Application No: M/91/21/PL
Site Address: 27 Central Drive Middleton-On-Sea PO22 7TT
Description of works: Variation of condition 2-approved plans & removal of condition 4-materials included on plans imposed under M/25/19/PL.

Thank you for your internet representation made on 4th August 2021 which has been recorded as an objection with the comments as follows:

On behalf of concerned members of the Elmer Beach Residents Association (EBRA) who live in close proximity to this build, the EBRA Board of directors objects to planning application M/91/21/PL, 27 Central Drive, Elmer for the following reasons:

PROJECT	27 Central Drive - Elmer Beach	DATE	16/09/18
TITLE	Proposed South Elevation	DRG NO	IBA/507/05
SCALE	1 : 50	REVISIONS	B

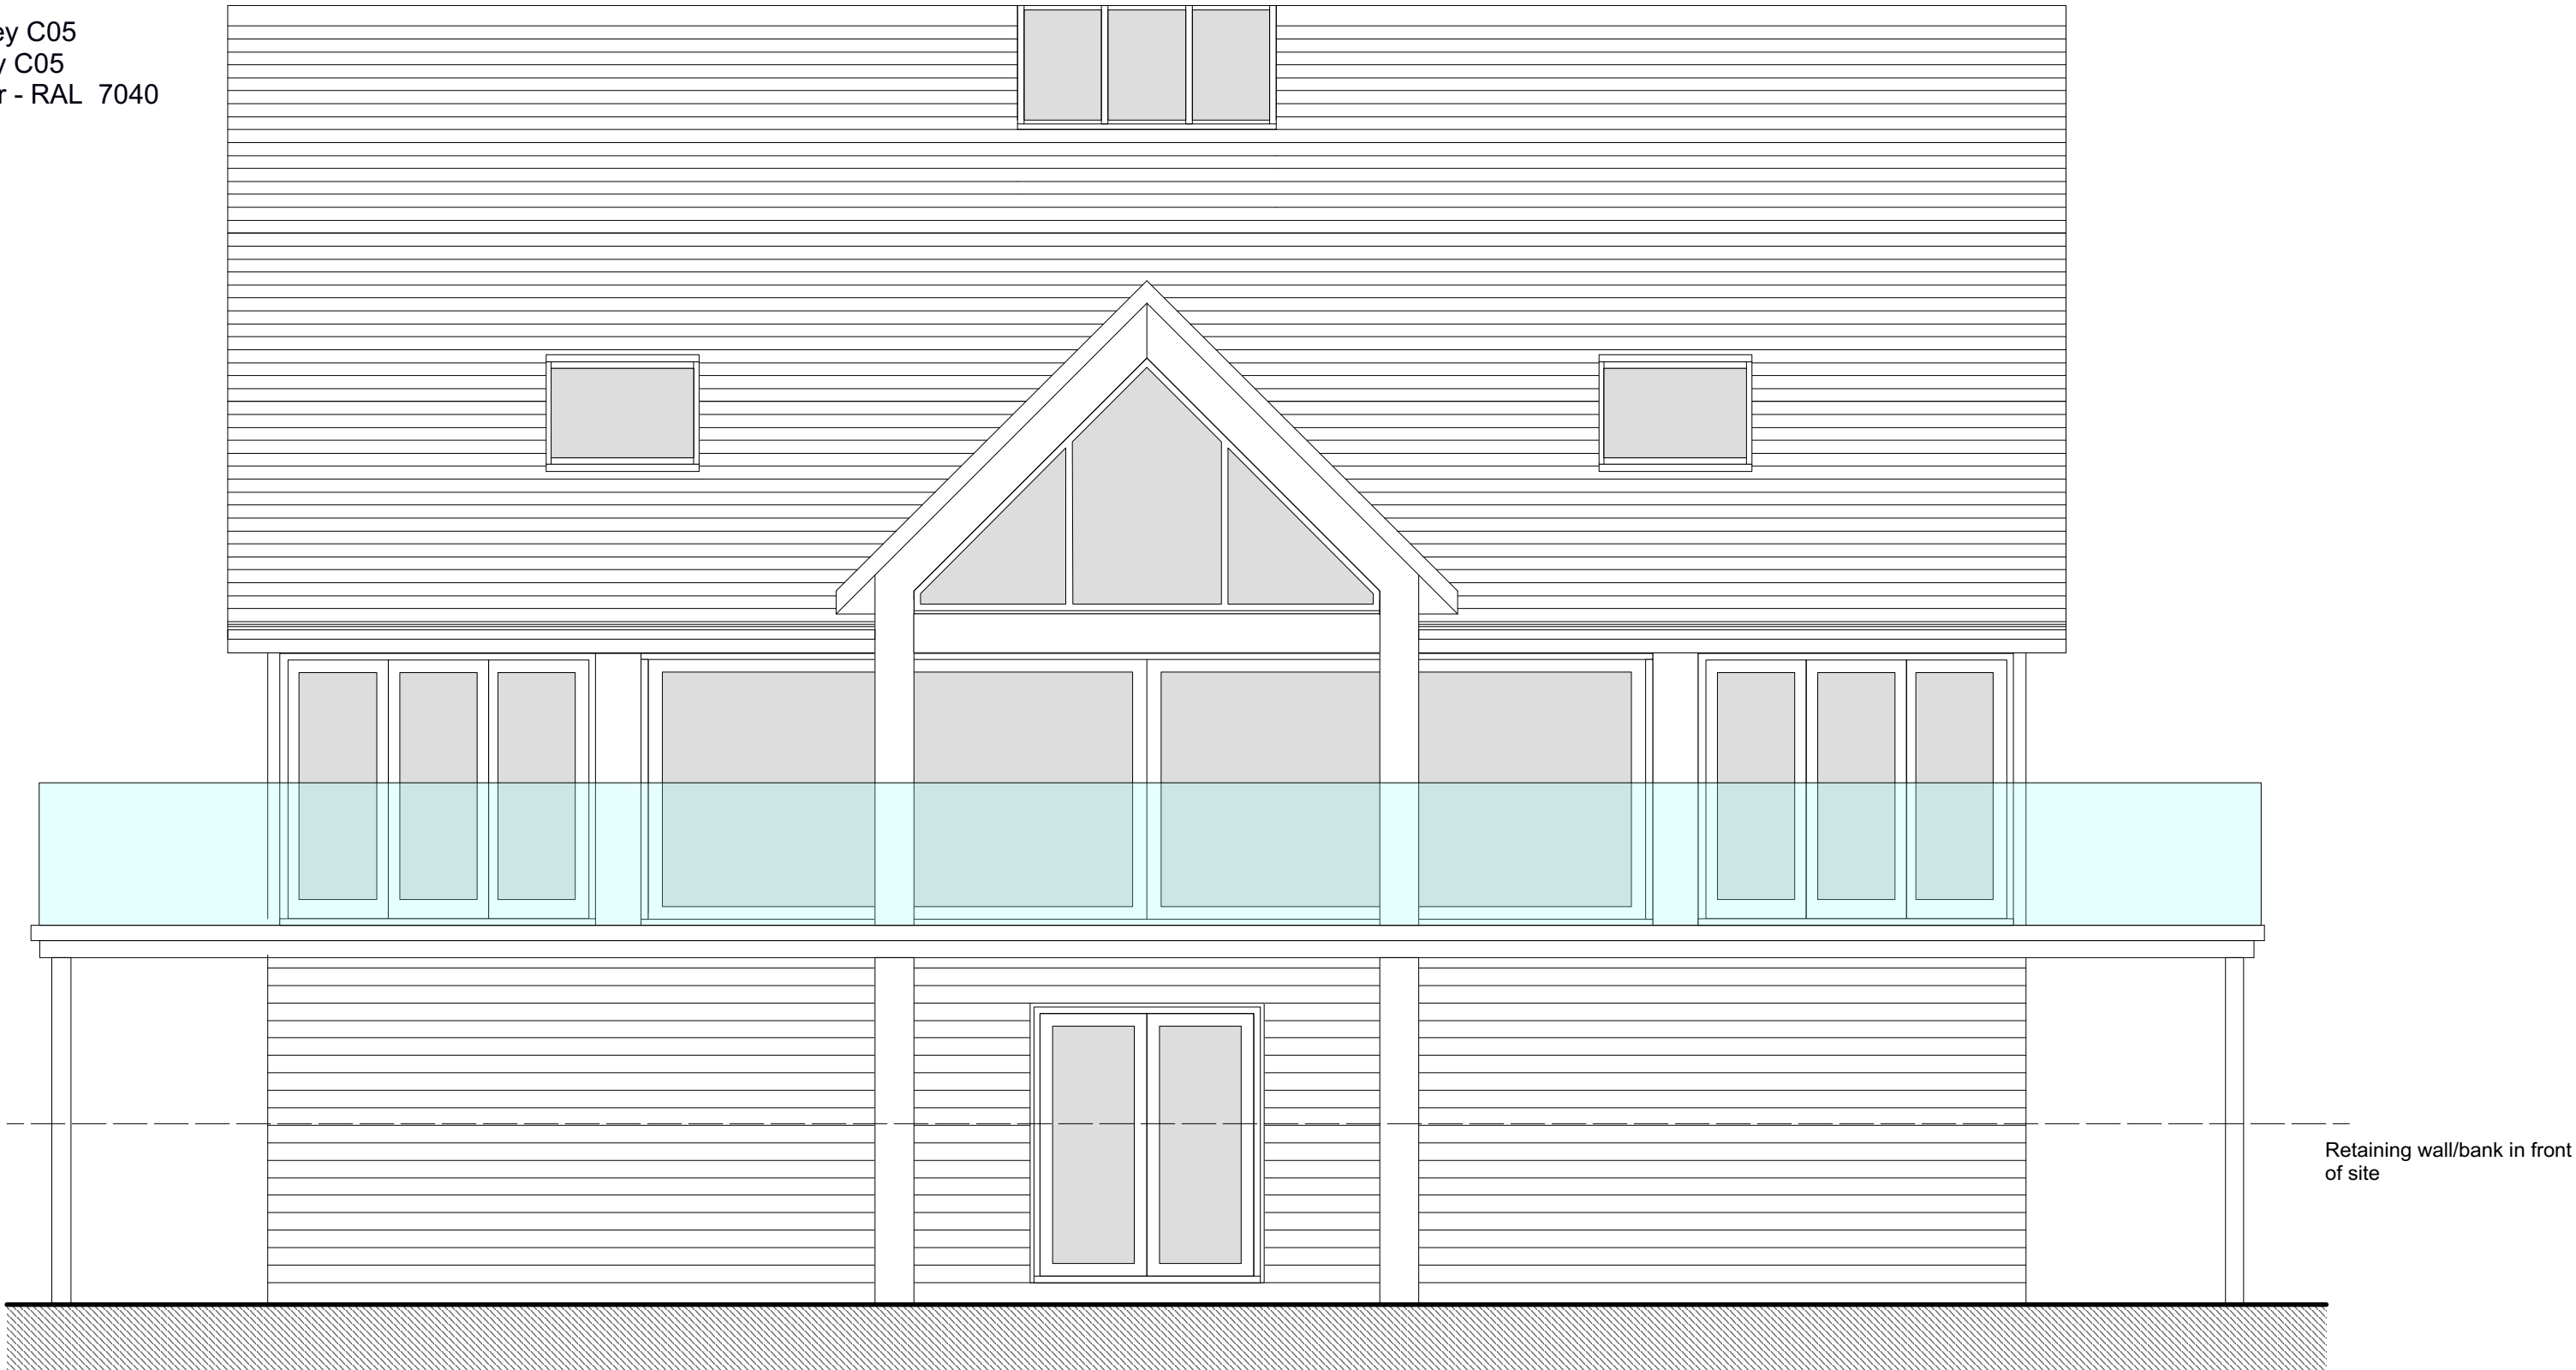
- 1) The original agreed planning permission M/25/19/PL indicated that the approved height of the building sympathetically aligned to that of the adjacent and neighbouring properties.
The actual build height exceeds this by up to 2 metres. This actual height is unacceptable as the building now overshadows surrounding properties and is not sympathetic to those residents of the Elmer Beach Estate.
- 2) The actual build height is not present in any previous or current design documents, the only reference to height was from the North and South elevation drawings, which clearly depicted the height as comparable to the existing adjacent property, 25 Central Drive.
- 3) The new un-agreed height sets an unacceptable precedence of new build height across the Elmer Beach Estate for all future building developments.
